**From:** Katie Kurek [REDACTED]  
**Sent:** 24 May 2018 10:52  
**To:** Anita Gardner  
**Subject:** RE: EP/7/18/PL 2 Houses Land Rear of Beechlands

DRAWING TITLE
Proposed Site Plan, Block Plan
and Location Plan

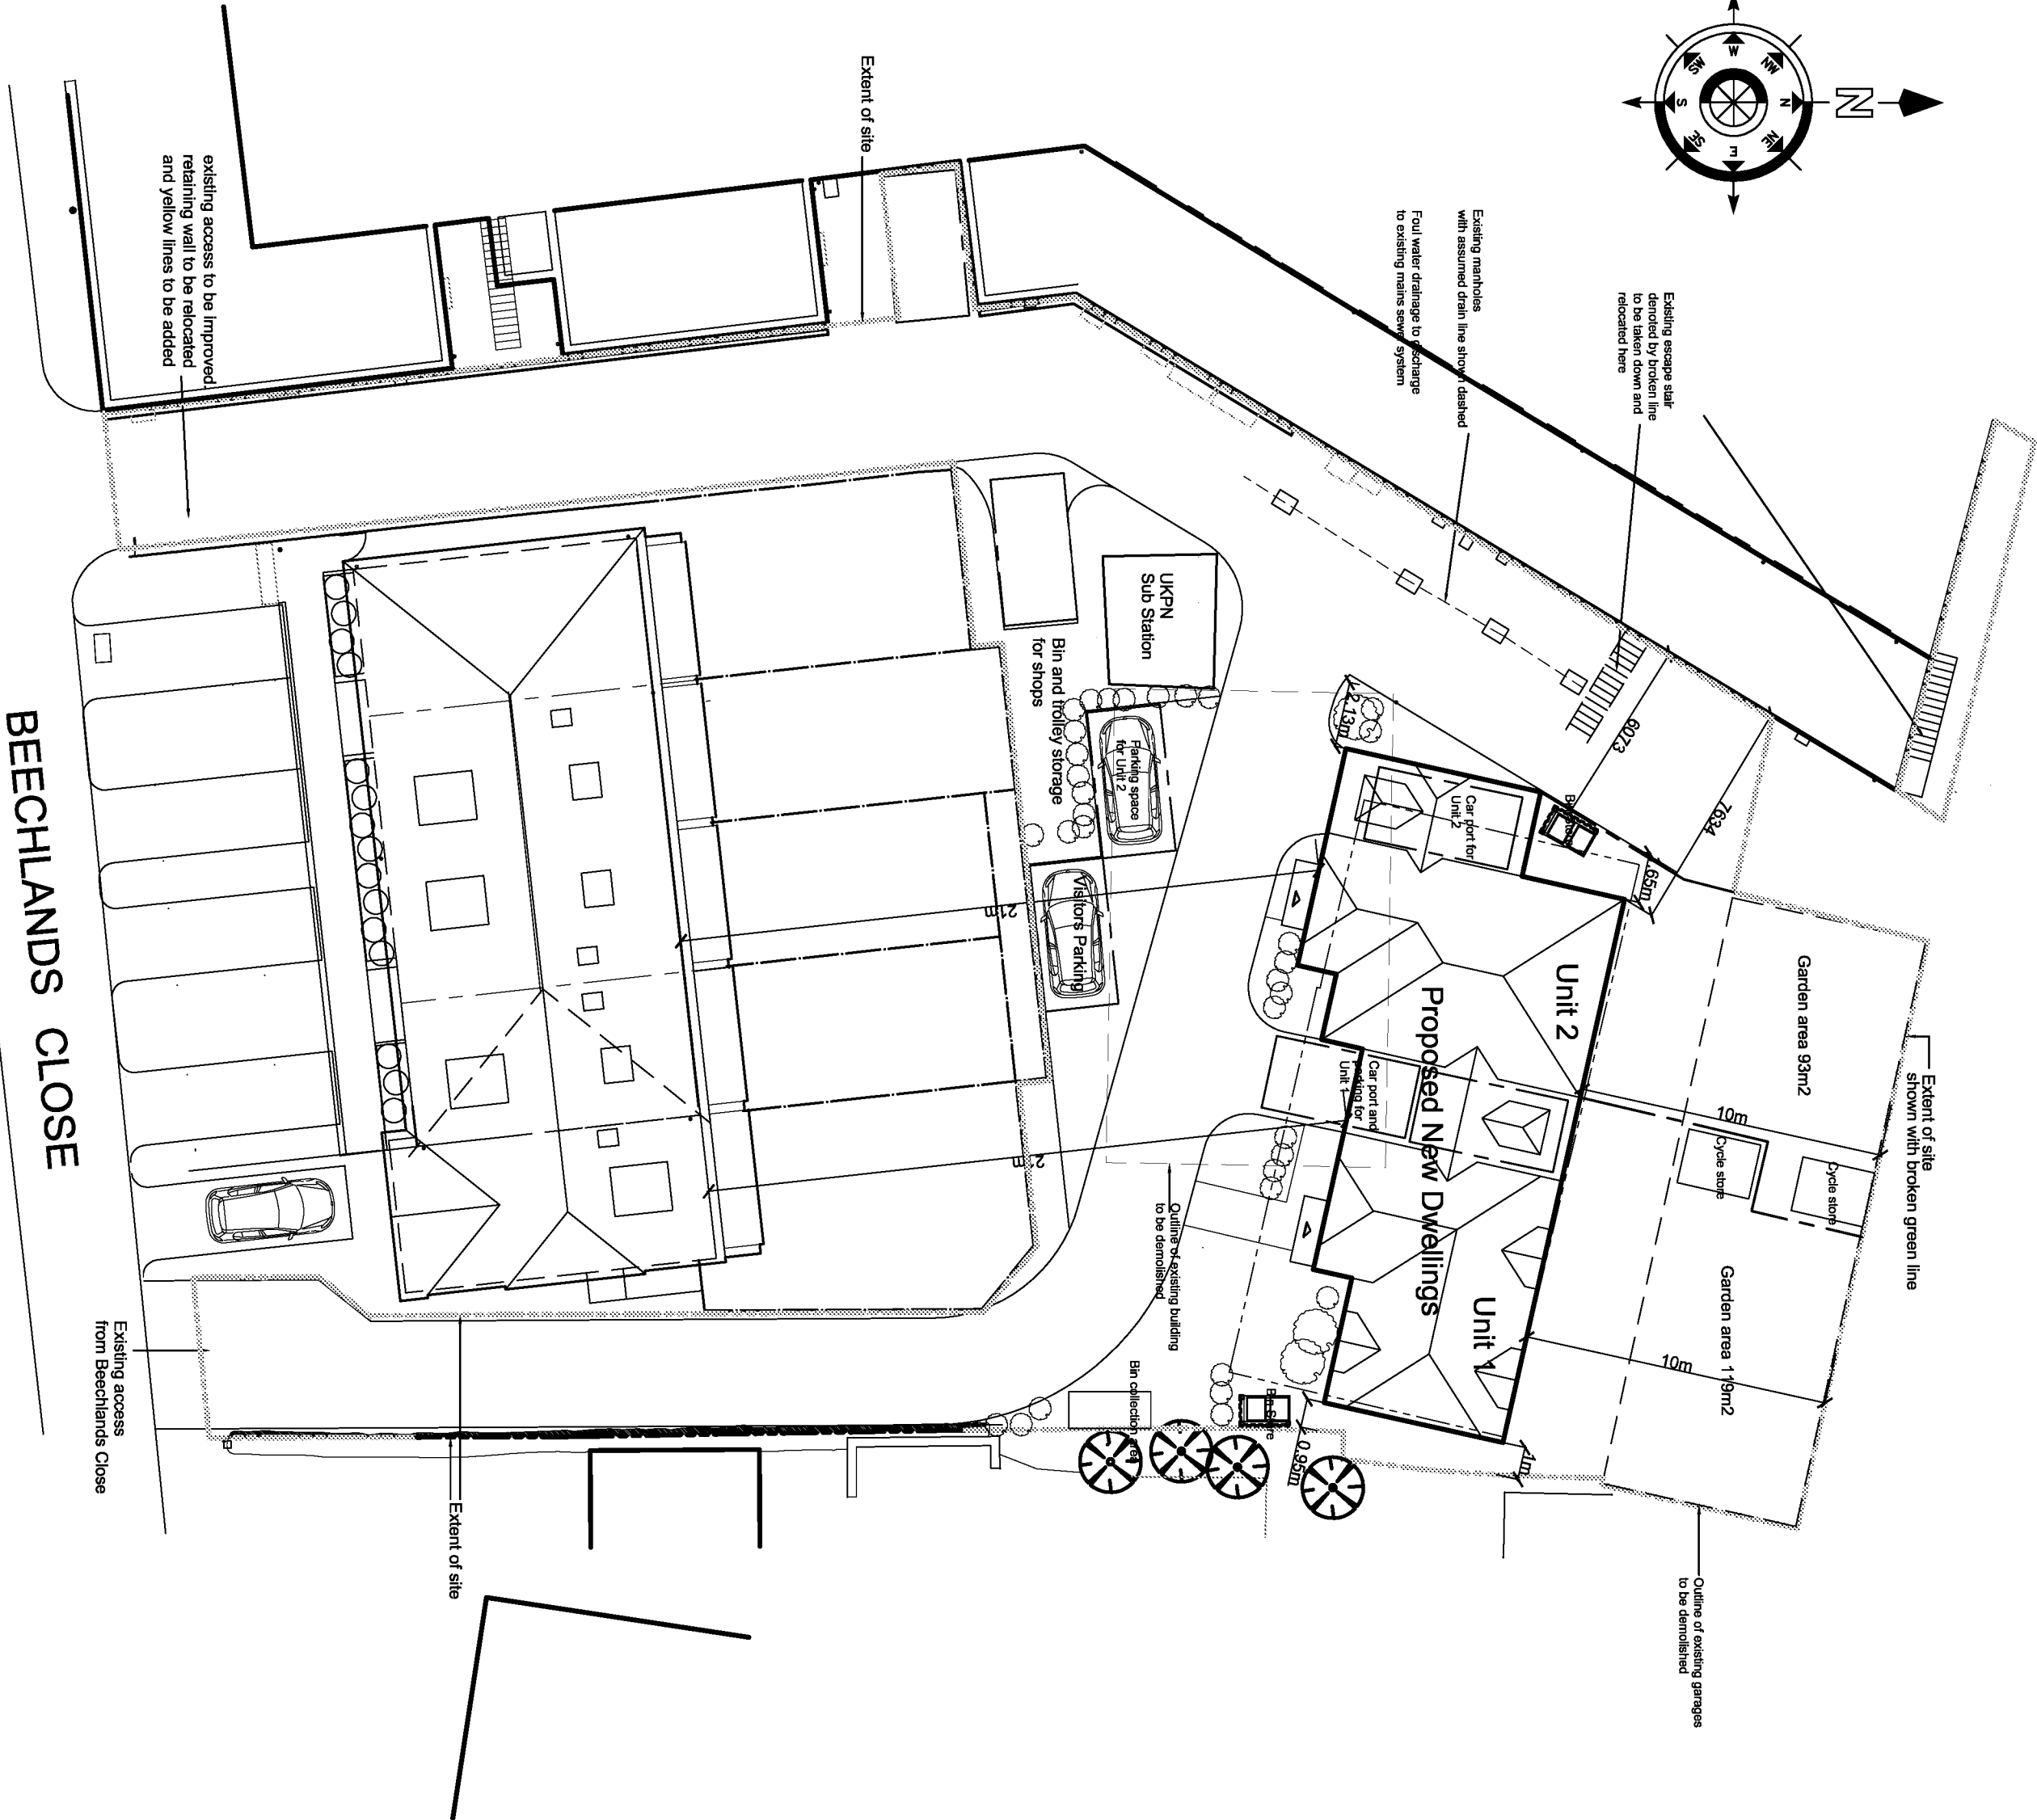
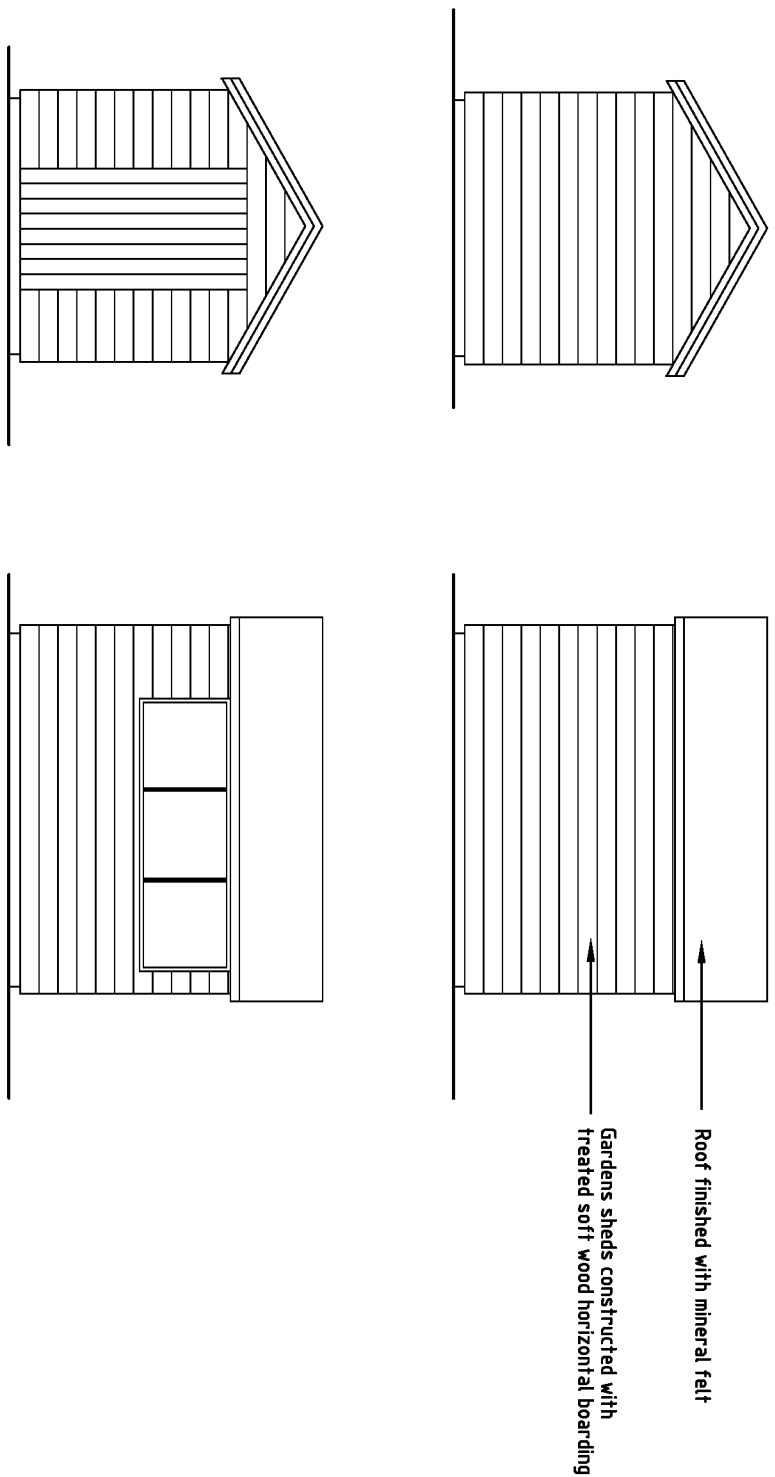
I visited the site yesterday and observed approx. 6 cars parked to the rear which I presume are staff for the shopping parade or overspill resident parking from nearby. The proposed 2 x residential dwellings is a reduced scheme which provides a sufficient level of parking in line with the WSCC Car Parking Demand Calculator. Beechlands Close is no-through with some on-street parking resulting in low speeds and manoeuvring. The site is accessed via the one-way parade 'Sea Road'. The junction of Sea Road and Beechlands Close is protected by junction markings to deter cars from parking in this location. Any illegal parking could be dealt with as an offence under Section 22 Road Traffic Act 1988 (leaving vehicles in a dangerous position on the road including verge) and Section 137 Highways Act 1980 (wilful obstruction of the free passage along a highway.) Both of these acts are enforceable by Sussex Police.

I observed two cars parked close to the junction with Sea Road but not covering the double yellow lines. This had the effect of slowing traffic and considering that sufficient level of parking provided for the proposal do not consider overspill parking would be to a 'severe' level. Displacement of cars observed to the rear of the site would not be considered a highway safety reason for refusal considering the before mentioned road protection markings in the vicinity. You may wish to consider the effect of the displacement of these cars from an amenity point of view. The onus is on the driver to park in location that would not detrimentally impact highway safety or block the free flow of traffic.

The LHA therefore consider it would not be reasonable to insist on further road protection markings as part of the planning application considering on-street parking is an existing concern in the vicinity, the proposal itself is provided with sufficient parking, and road protection markings and parking bays deter further on street parking from occurring in locations that would be detrimental to highway safety. If residents/ members wish to put forward for additional road protection markings through a Traffic Regulation Order then this could be raised through the County Local Committee (CLC) meetings process.

With regard to access within the site for larger vehicles I note that point 6.2 of the Design and Access Statement sets out that refuse vehicles will not enter the site and bins will be collected by operatives from the store. With regard to emergency vehicle access I have copied in the Water & Access Manager for his comments regards accessibility for a pumping appliance to all proposed dwellings.
